**From:** [Douglas Cunningham](#)  
**To:** [Bruce Zhang](#)  
**Cc:** [Elizabeth Parker](#)  
**Subject:** RE: Oakdale West Estate Mod 5 (SSD-7348-Mod-5)  
**Date:** Tuesday, 11 August 2020 09:59:28

Thank you for referring Oakdale West Estate MOD 5 (SSD-7348-Mod-5) to the Office of Strategic Lands (OSL) for comment.

Figure 8 | Approved and Proposed Biodiversity Offset Sites

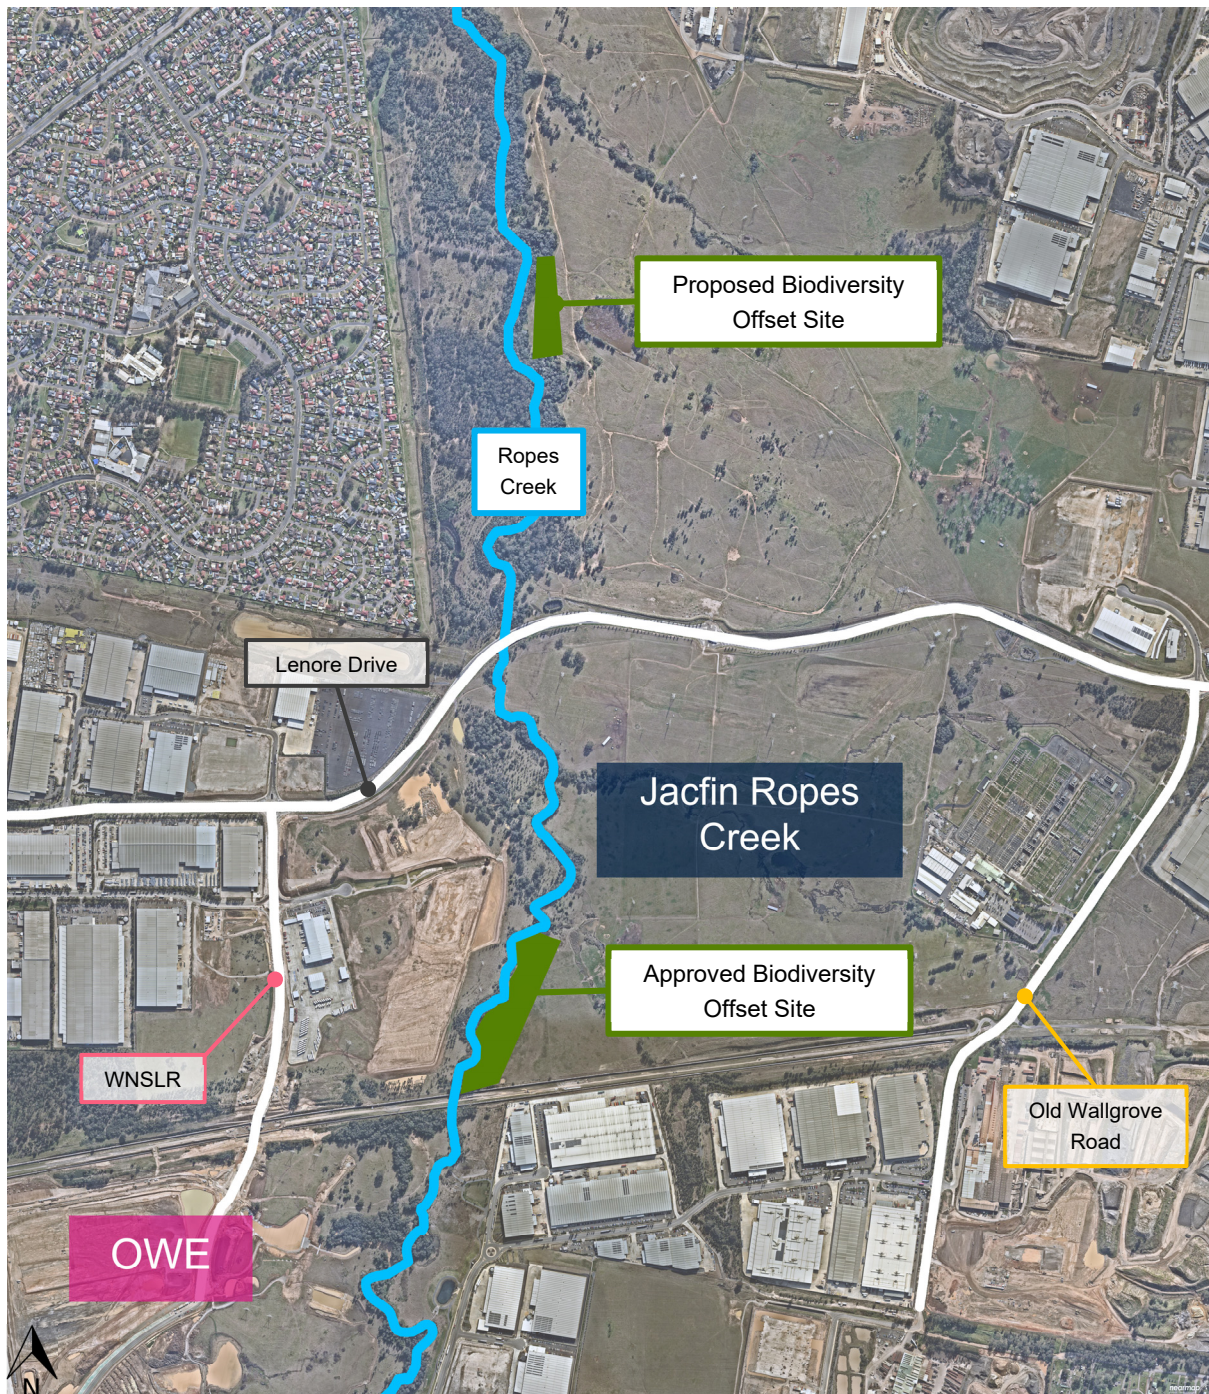
As OSL understands it, Mod 5 seeks to relocate the required offset planting, given the original planting area is unsuitable. Mod 5 proposes three potential sites, identified as 4267 and 4258. OSL supports the relocation of the offset planting site to the area known as 4267. OSL will not support planting occurring in the two locations identified as 4258 given they will be impacted by adjacent construction works soon to be undertaken.
